## EL PASO COUNTY STORMWATER MANAGEMENT PLAN CHECKLIST

EPC Project Number: SF2211

SITE GRADING & EROSION CONTROL PLAN

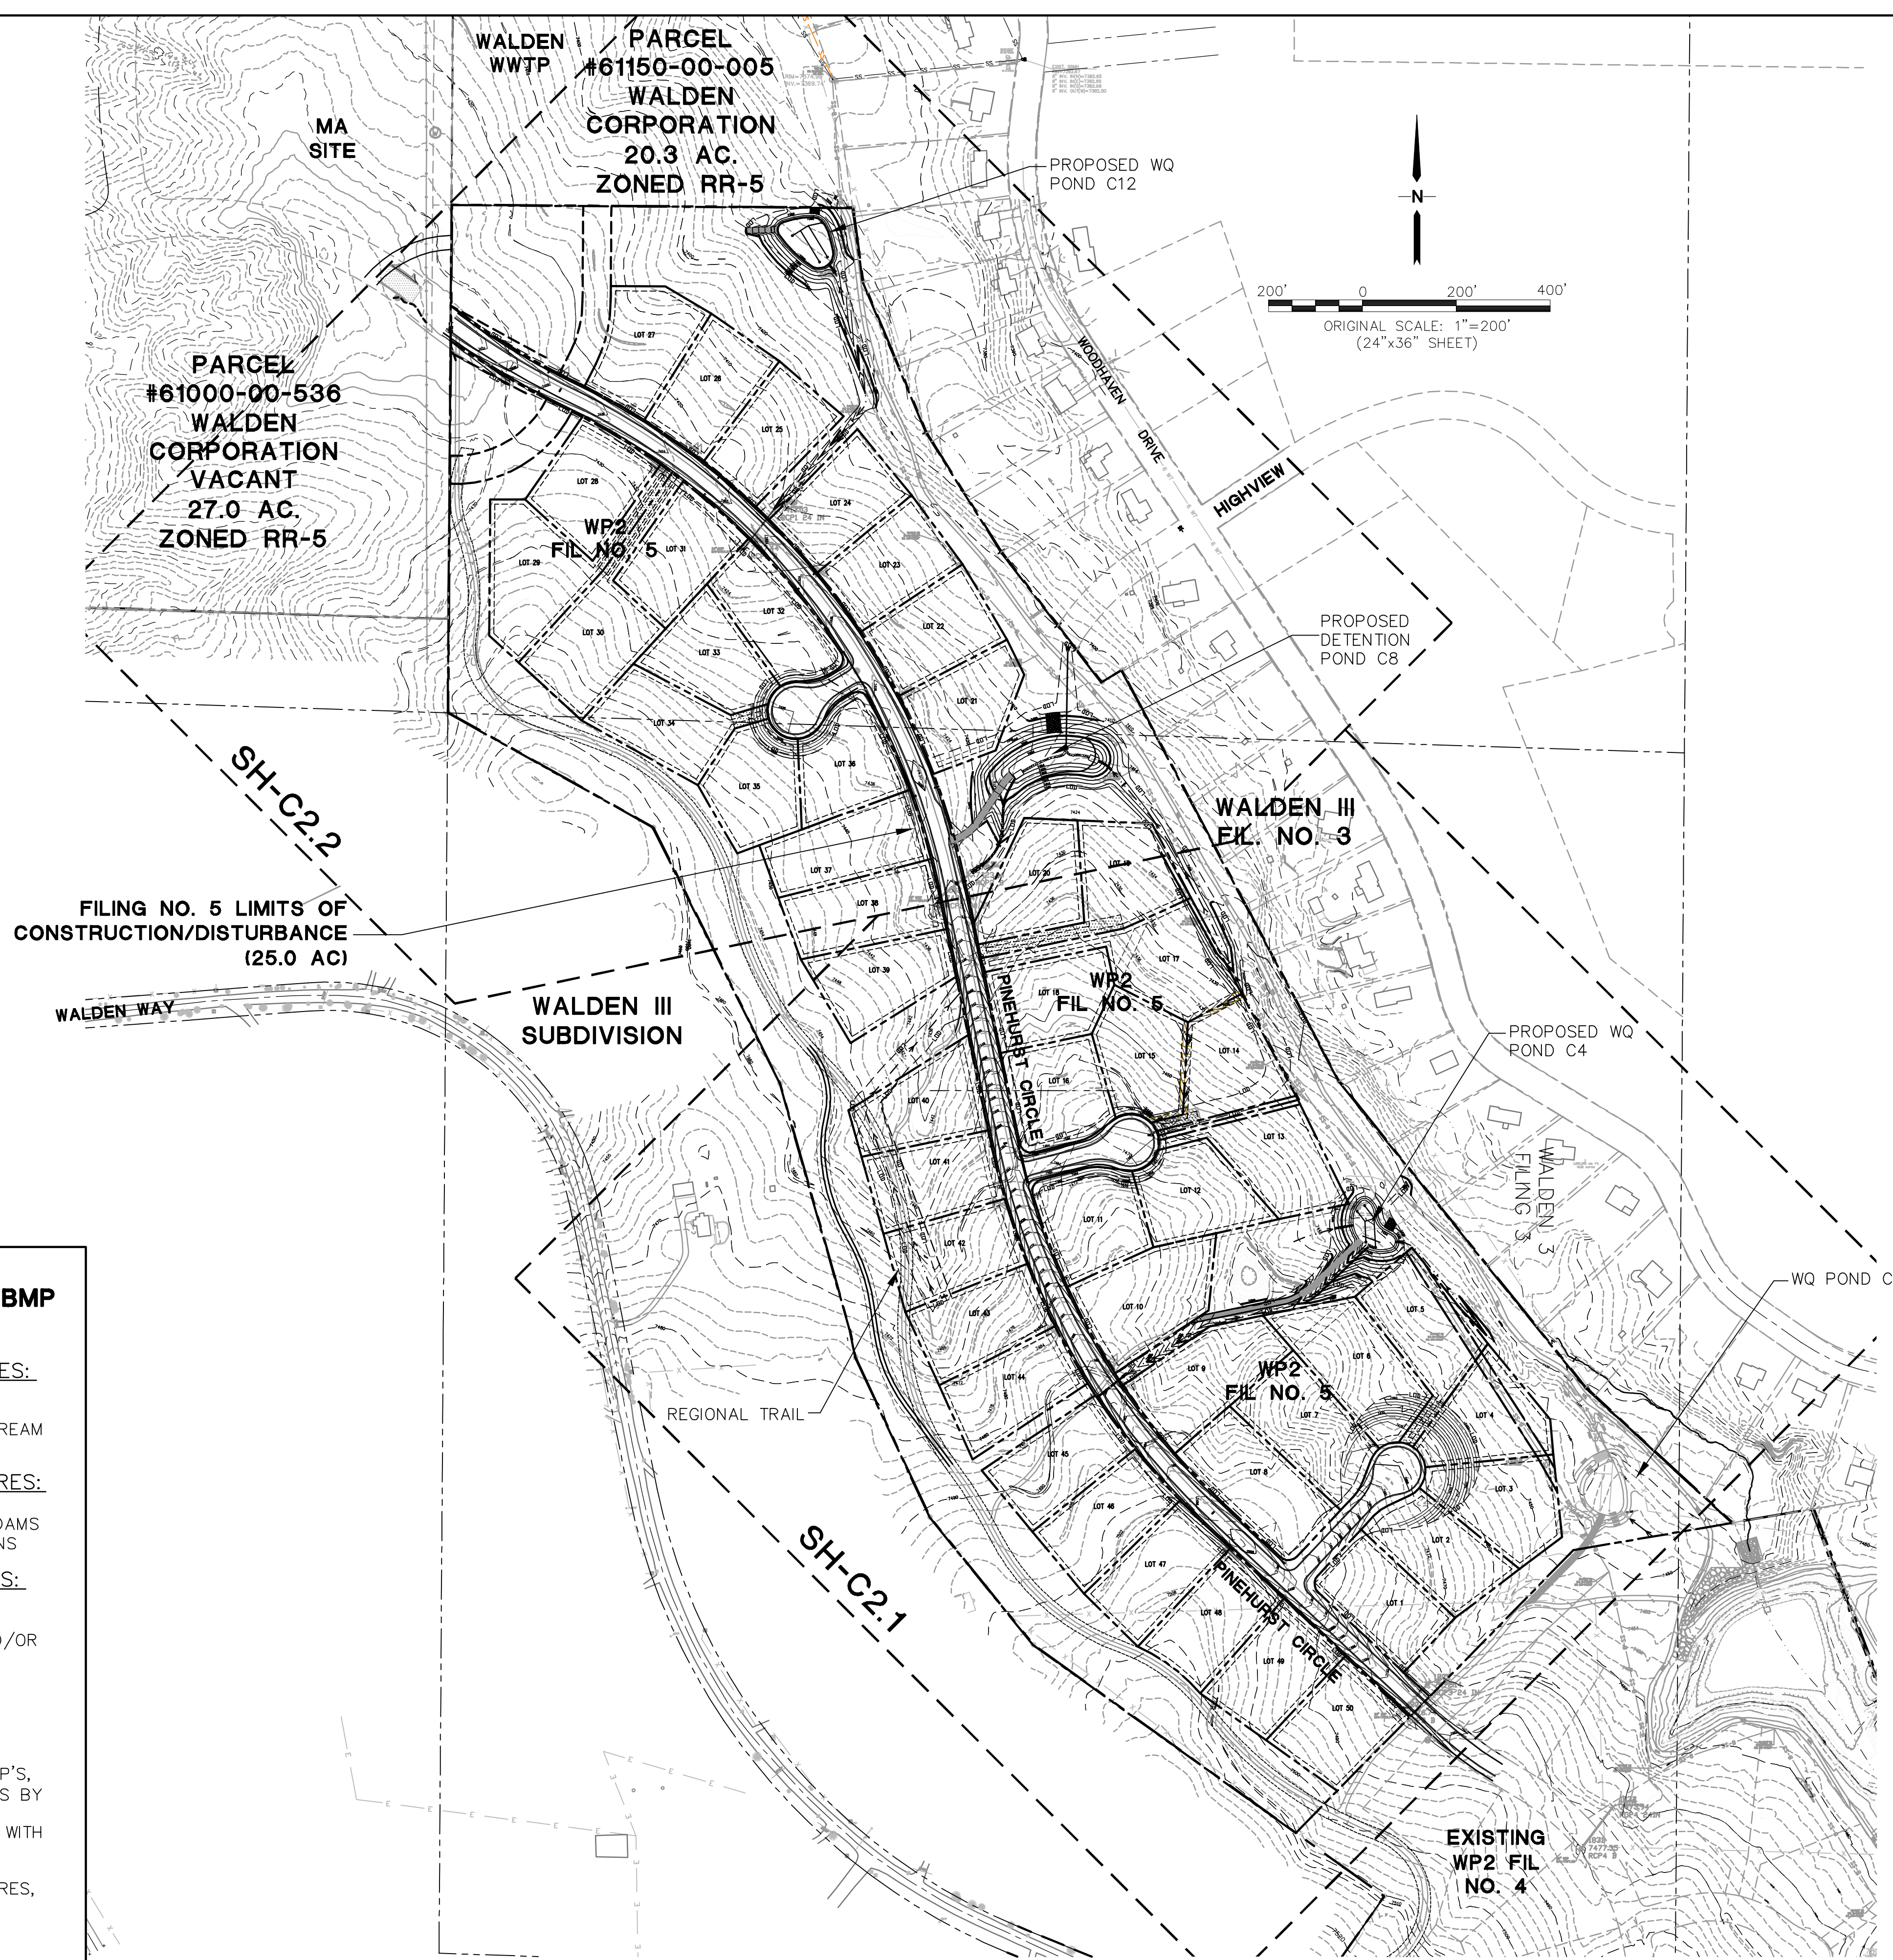
|   |   | Applicant | EPC |
|---|---|-----------|-----|
| 17b   | flow arrows to depict stormwater flow directions  | Y         | N   |
